**KIRKLEES METROPOLITAN COUNCIL
INVESTMENT & REGENERATION SERVICE**

**DELEGATED DECISION FOR APPLICATION FOR CERTIFICATE OF
LAWFUL DEVELOPMENT**

Reference no.: 2023/CL/92696/W

Site: 56, Greenhill Bank Road, New Mill, Holmfirth, HD9
1ER

| Indicative Site Sections                                |                                        |                                 |                                       |                                                                |

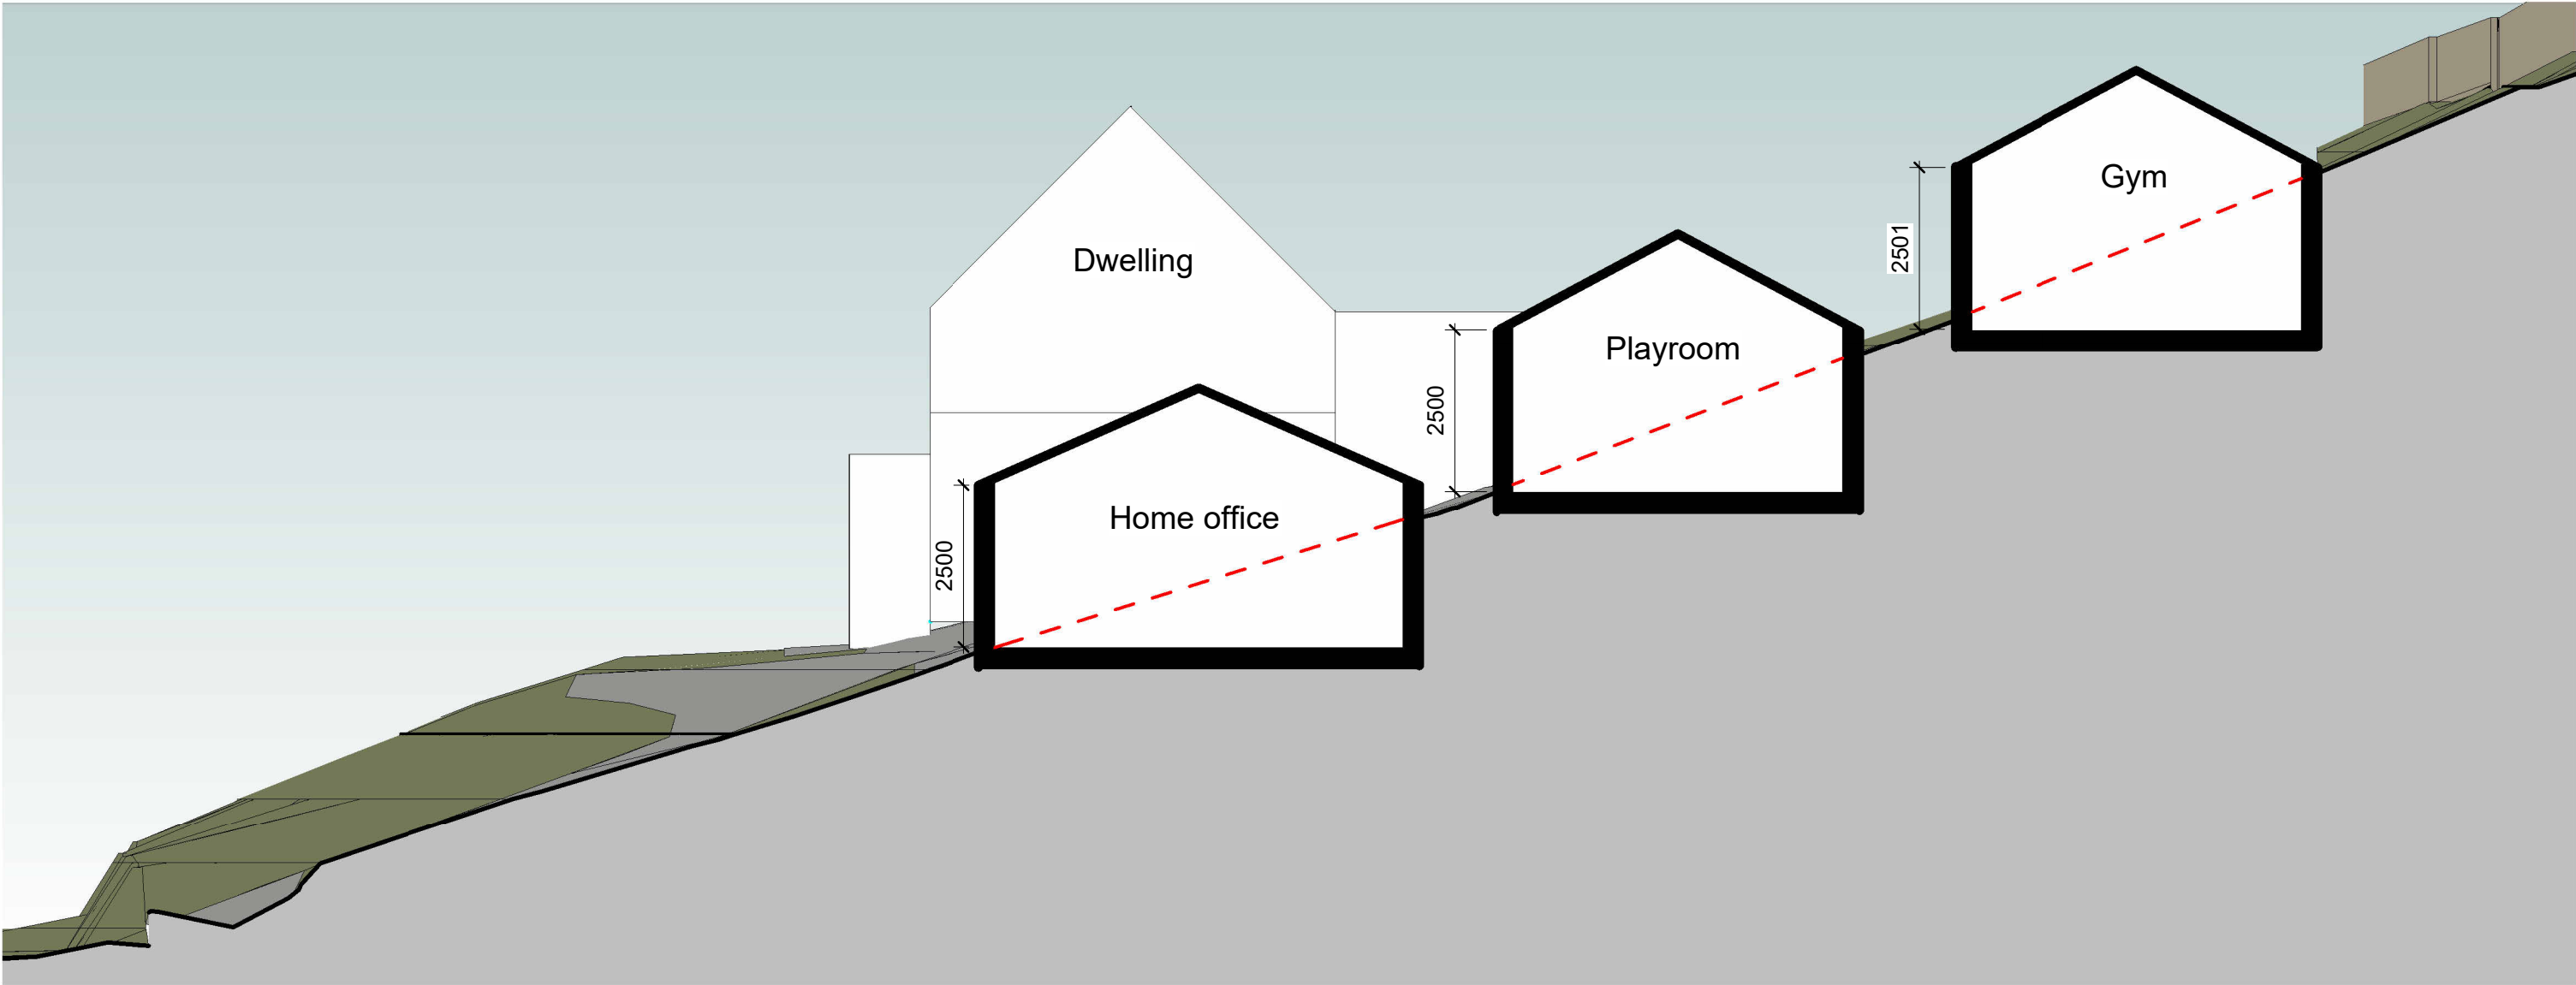
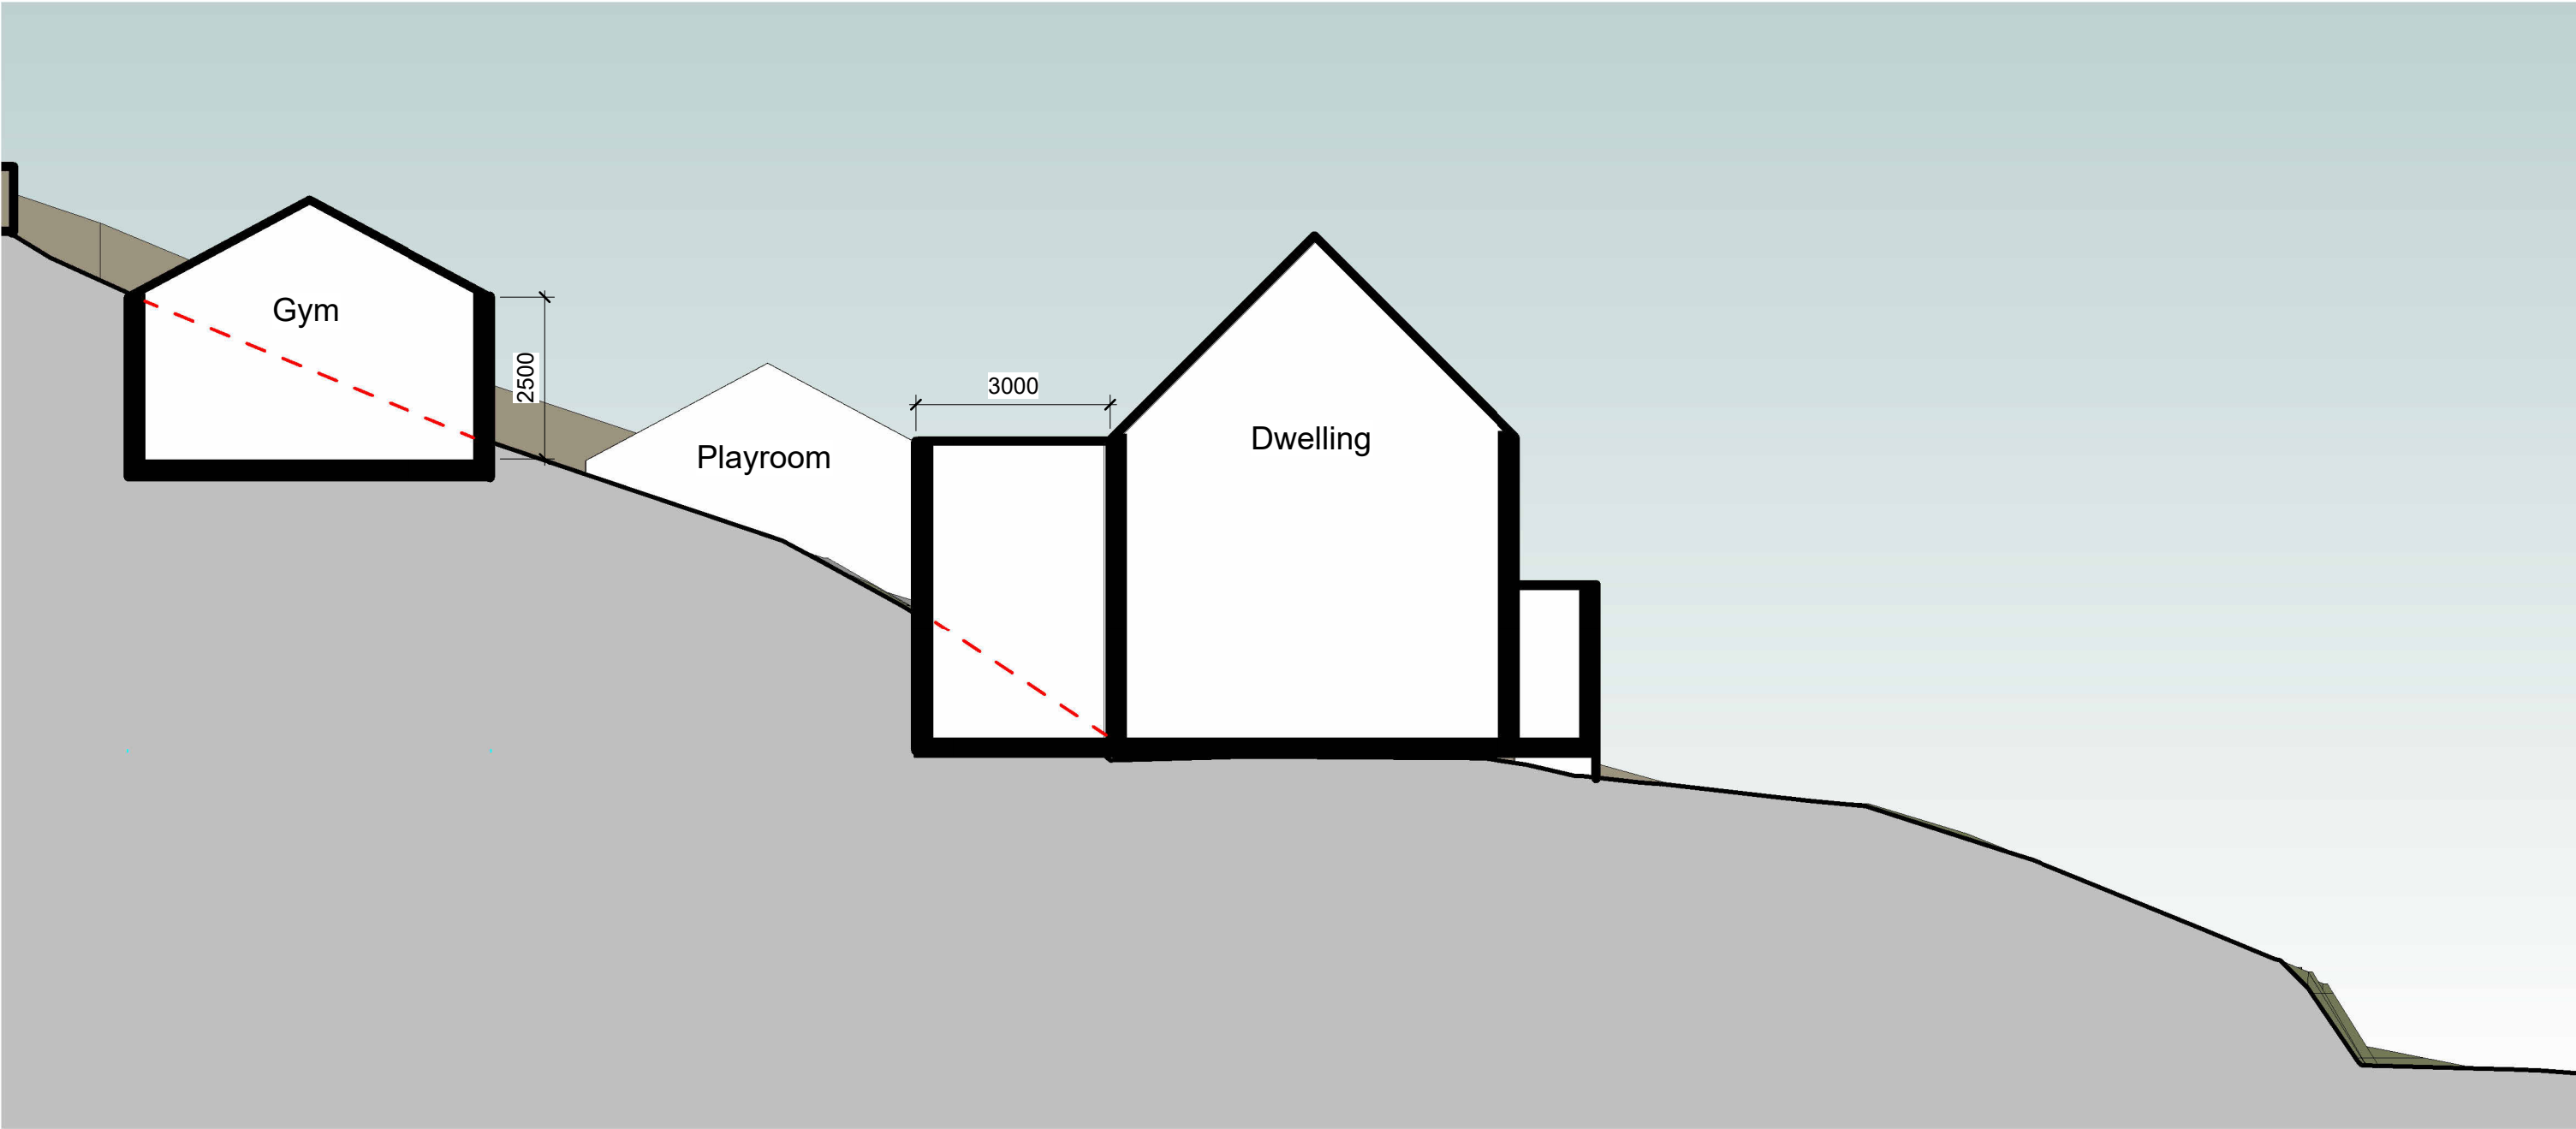
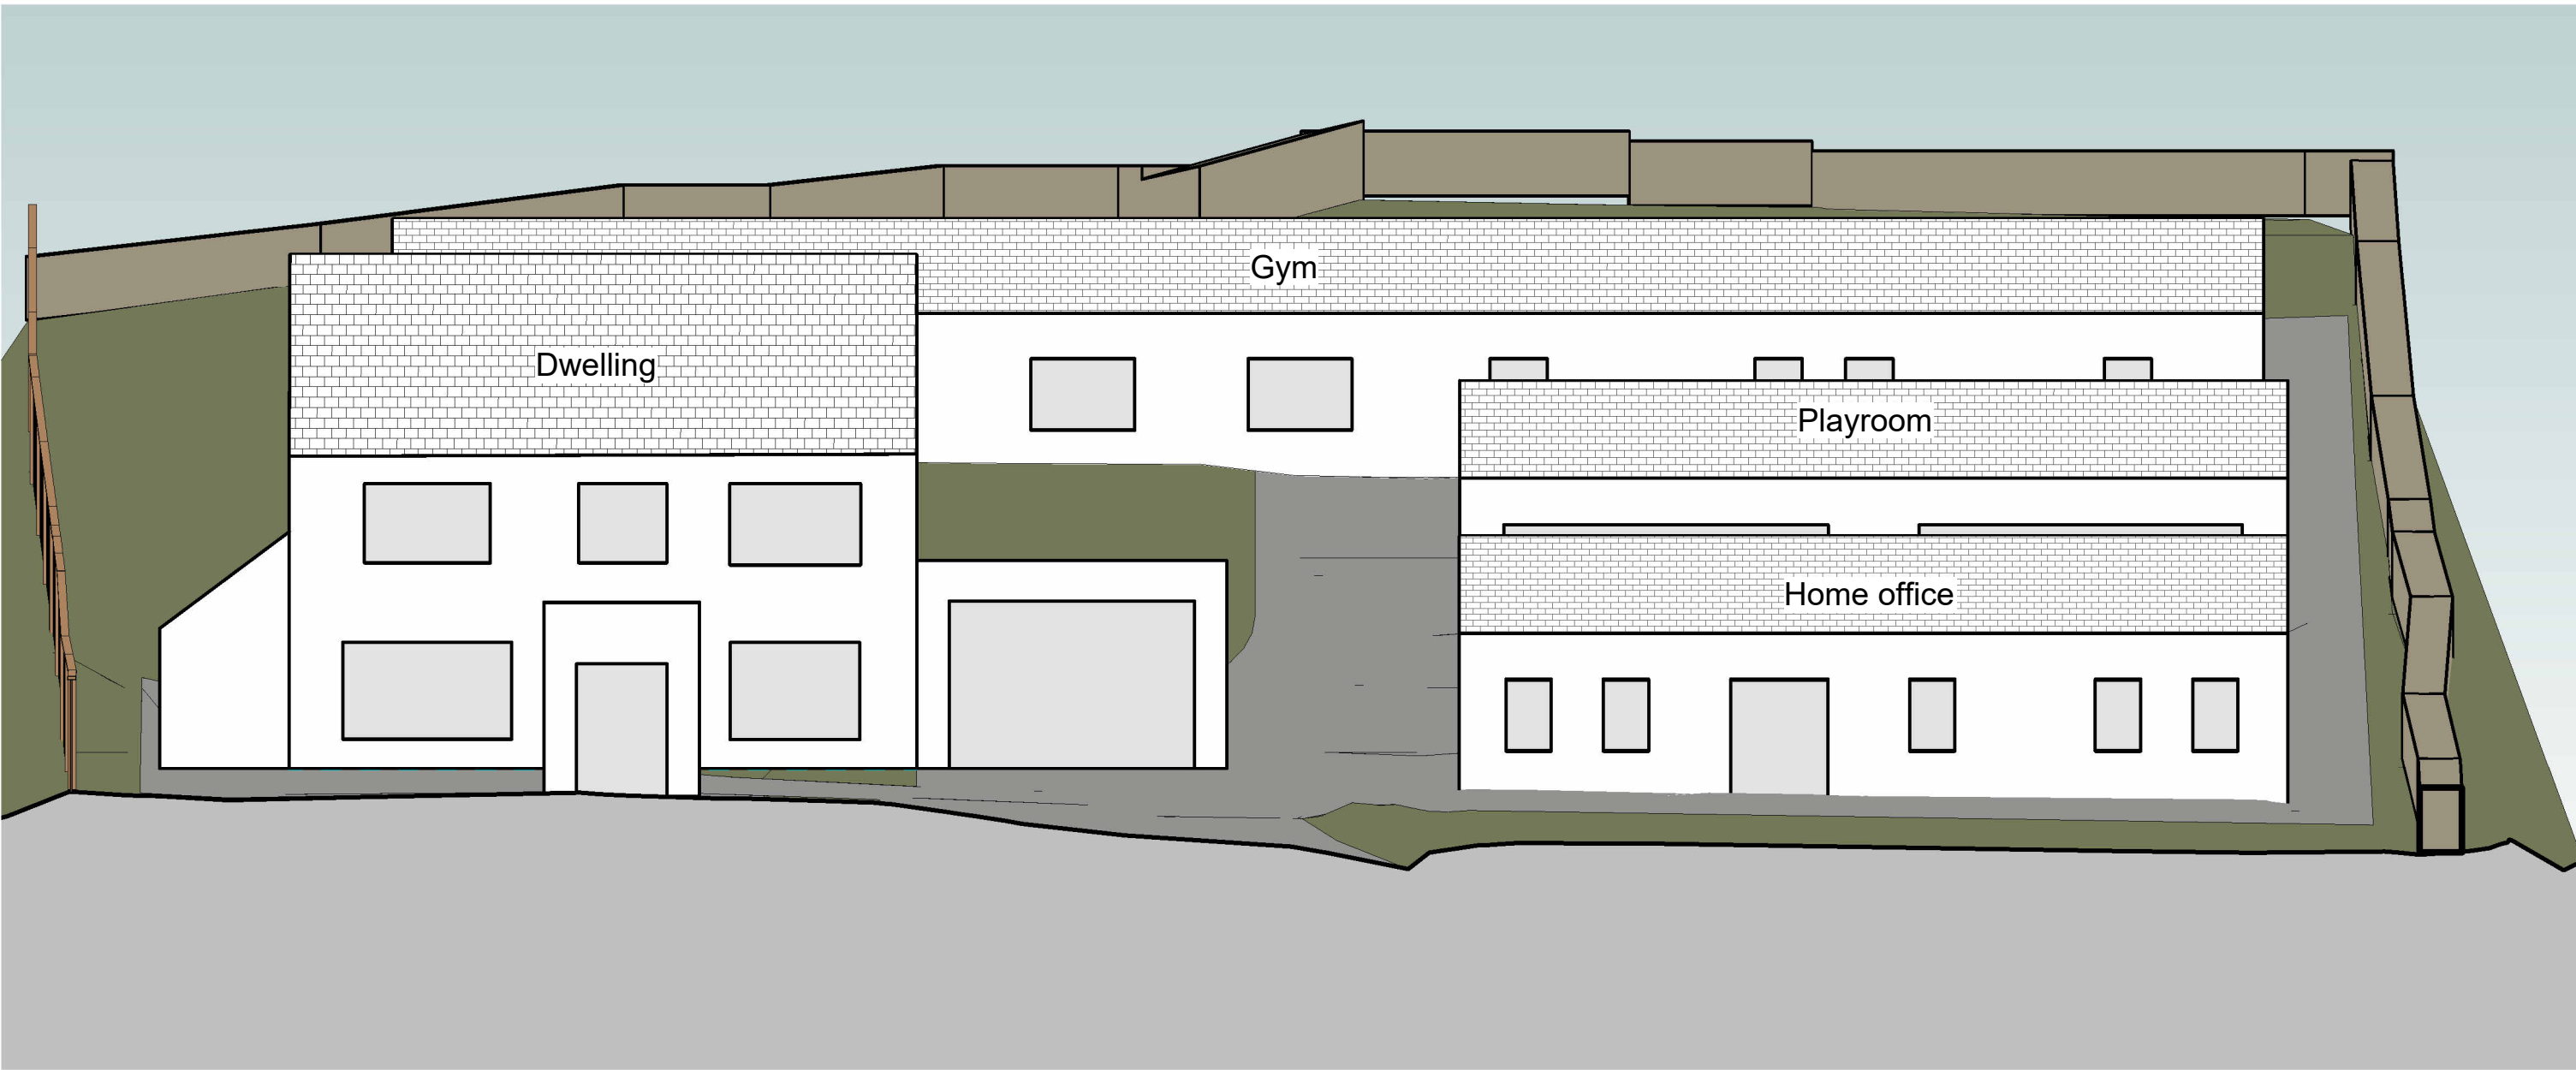
Comment: The submitted elevations show that all three outbuildings would be within these limits (when measured from the lowest ground level adjacent to the development as per the Technical Guidance).

Comment: The submitted elevations show that all three outbuildings would be within this limit (when measured from the lowest ground level adjacent to the development as per the Technical Guidance).
